# City of Ryde

**Proposed Residential Development (Phase 1) and Road Construction  
on the Royal Rehabilitation Centre Sydney site at Ryde (MP10\_0189)**

**ATTACHMENT: City of Ryde submission for Phase 1 Residential for Royal Rehabilitation Centre Sydney and construction of Road 5 (MP10\_0189)**

**TREES TO BE RETAINED**  
(SUBJECT TO FUTURE ARBORIST REVIEW)

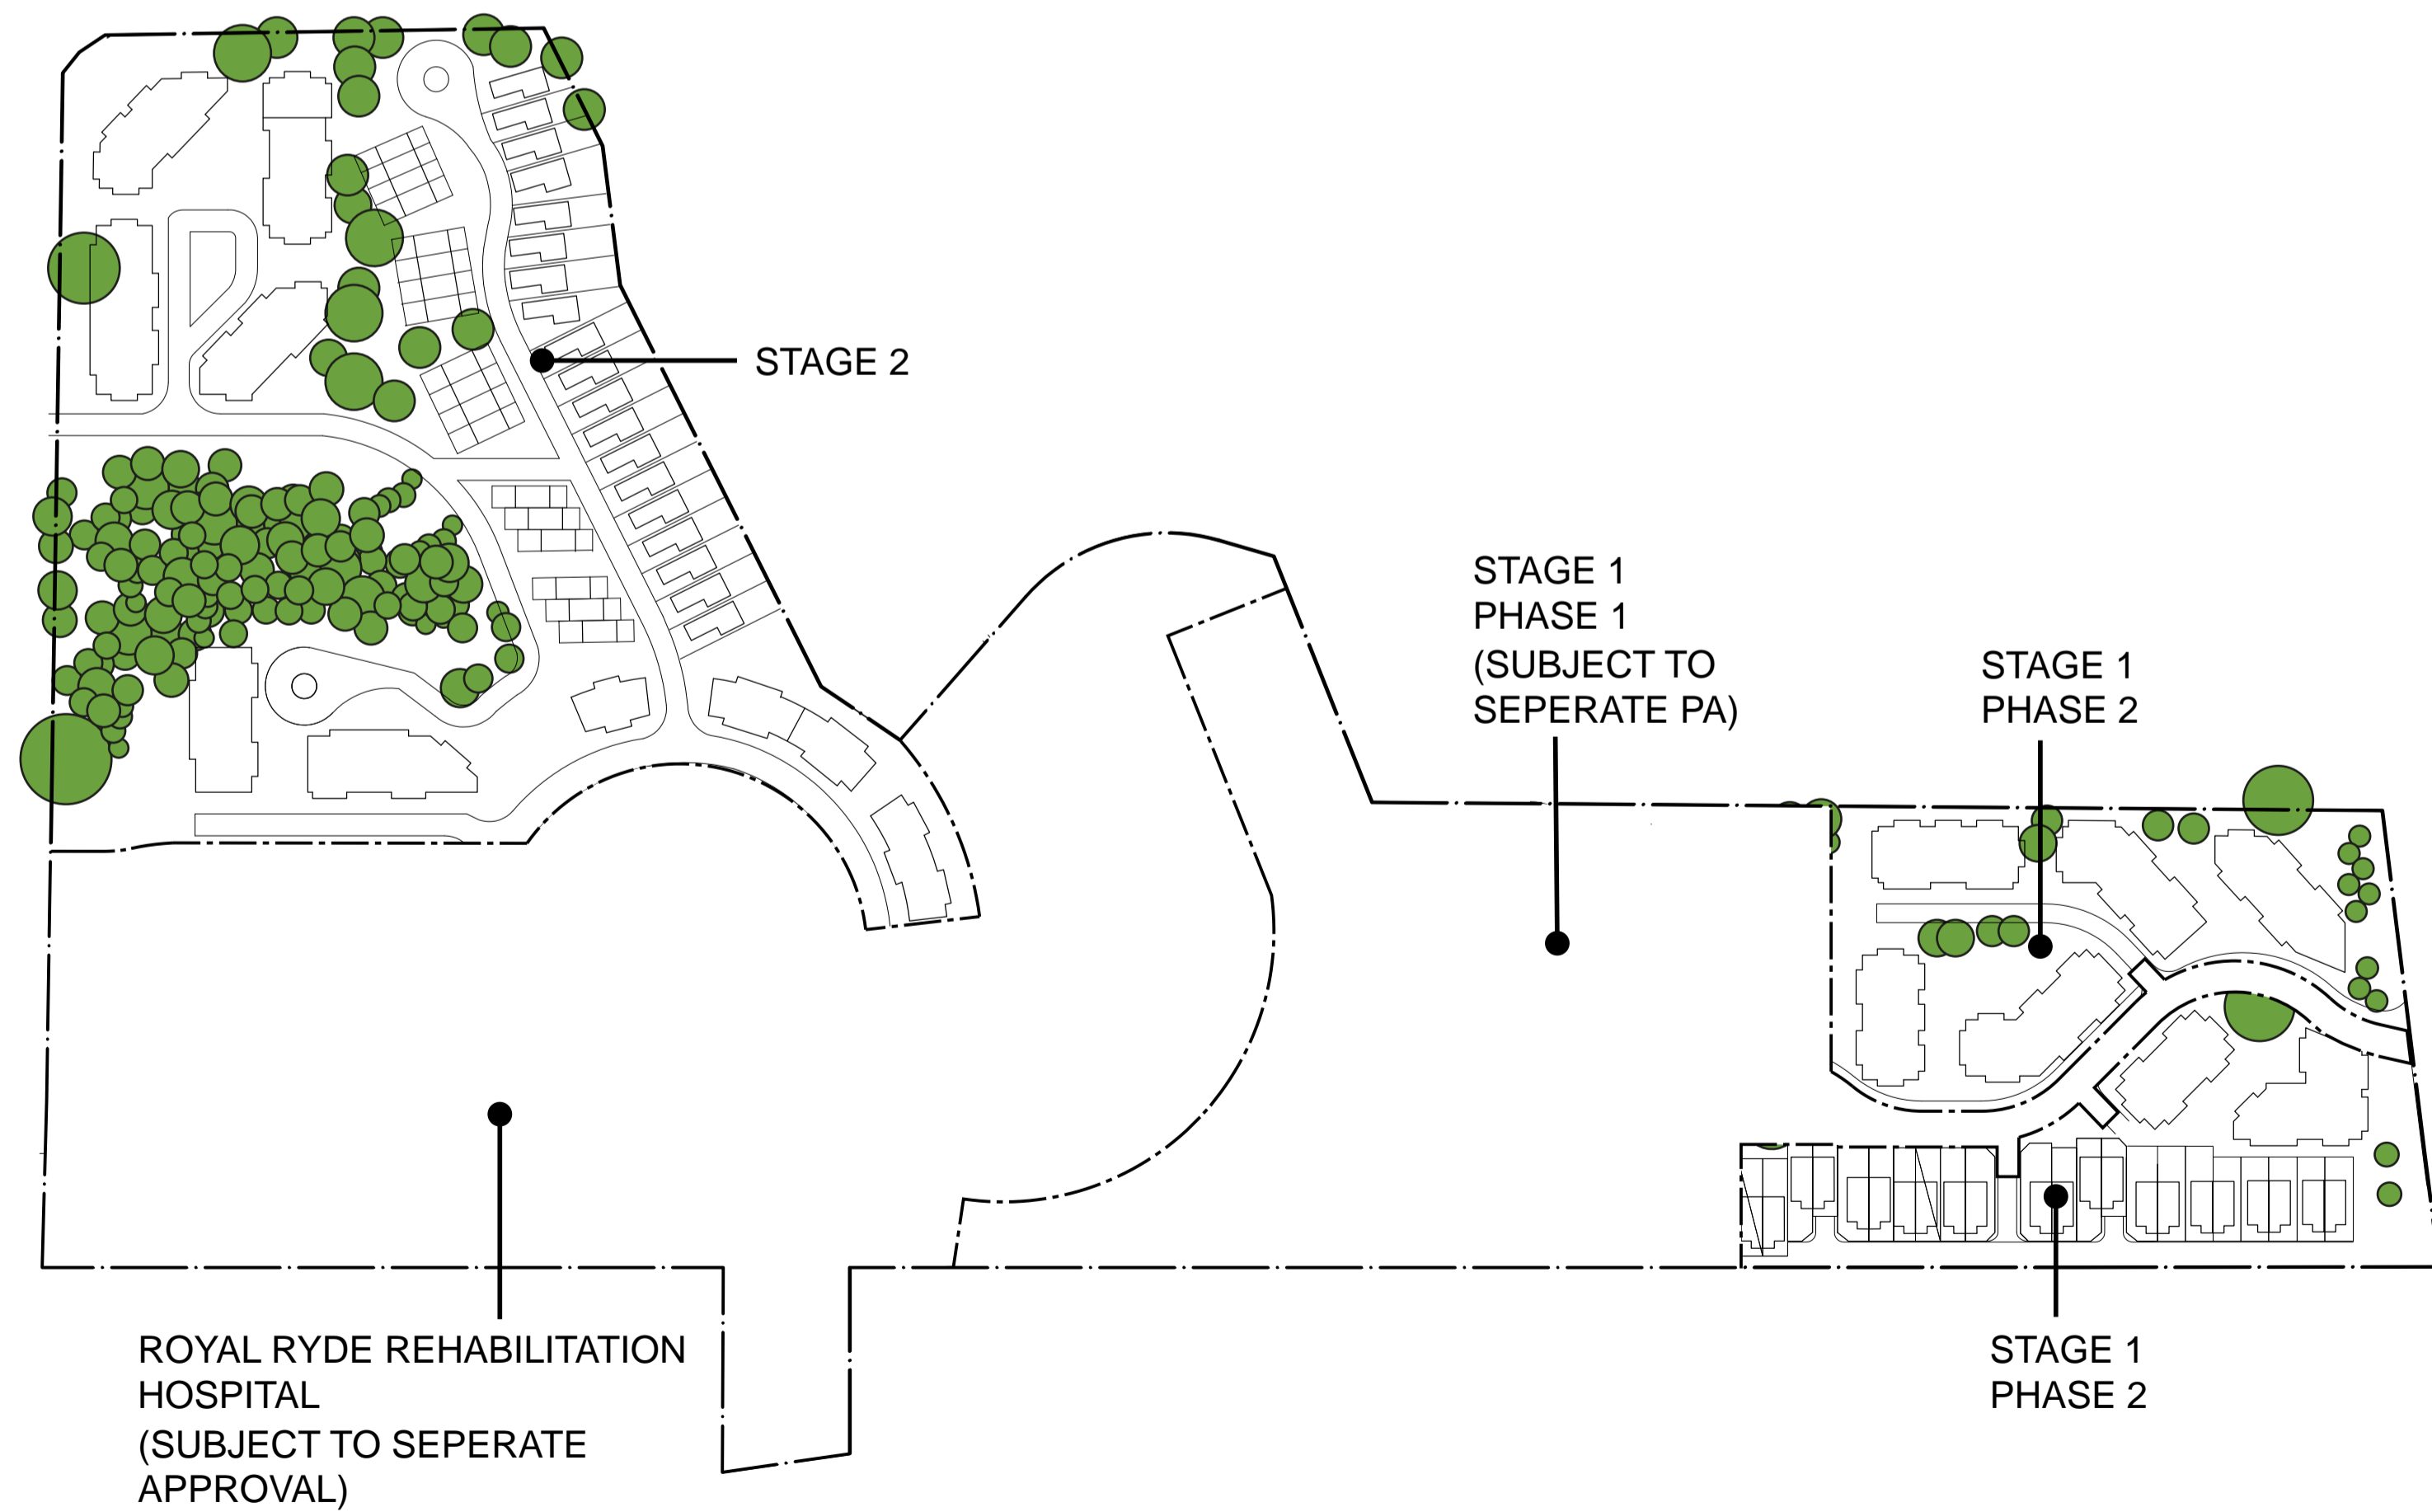
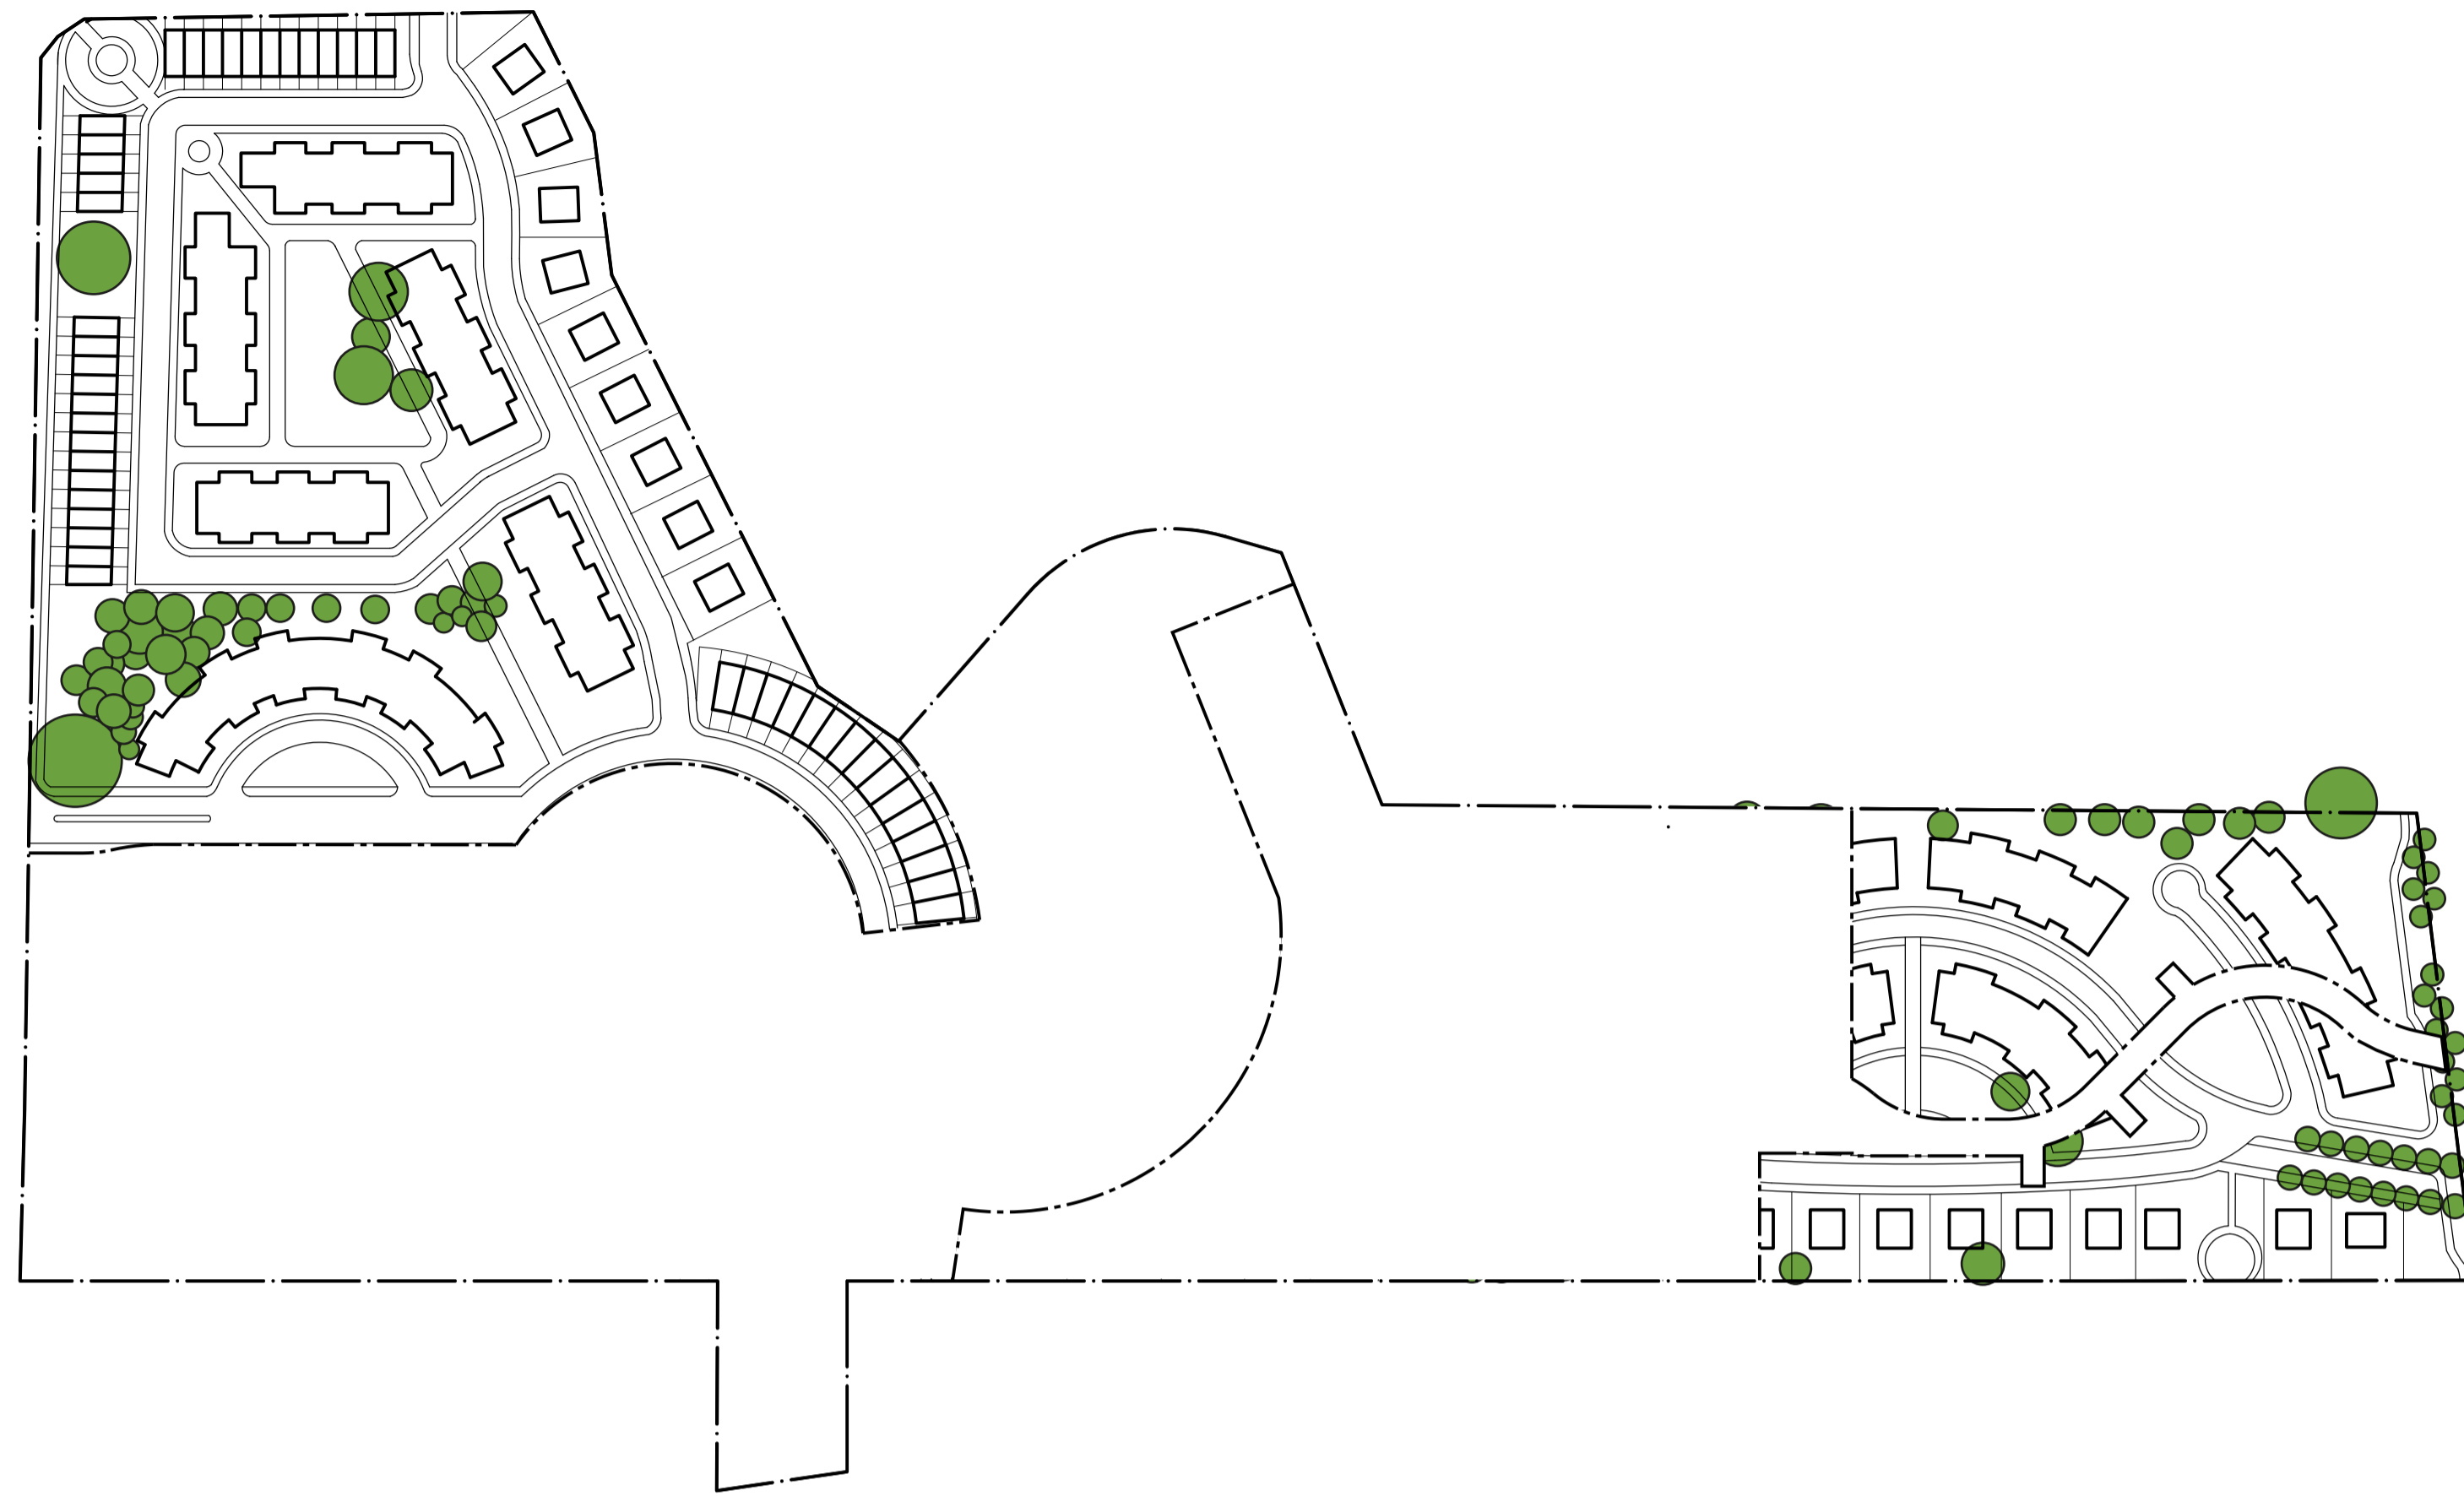
<p><b>AVENUE OF PALM TREES</b></p>	<p>The relocated road will severely impact on the rows of established palm trees that form a vegetative feature of the site. It is understood that the trees are proposed to be taken up and relocated elsewhere on the RRCS site. The visual impact of the loss of this avenue of trees is of concern to Council and conditions should be attached to any approval to ensure that the trees area successfully transplanted and survive.</p>
<p><b>PUBLIC AND PRIVATE ACCESS INTERFACE</b></p>	<p>A matter of concern for Council that may not be easily addressed through consideration of the Phase 1 residential development by itself or later stages of the project is the fact that not all roads on the RRCS site are currently proposed to be dedicated. For example Road 5 is expected to be dedicated as a public road. However, it ends at the "Recreational Circle" which is not proposed to be dedicated. The southern connection to Charles Street (which is identified in the EA as the "main access point " for Phase 1 is actually over a private road that includes rights of access but will not be a public road. Instead of services being accommodated within the road reserve (which is the conventional approach), at this end of the site, they will be in easements alongside the road or in open space.</p> <p>Council s preference is that there should be no future confusion on who can use roads on the site. While there may be good reasons</p>
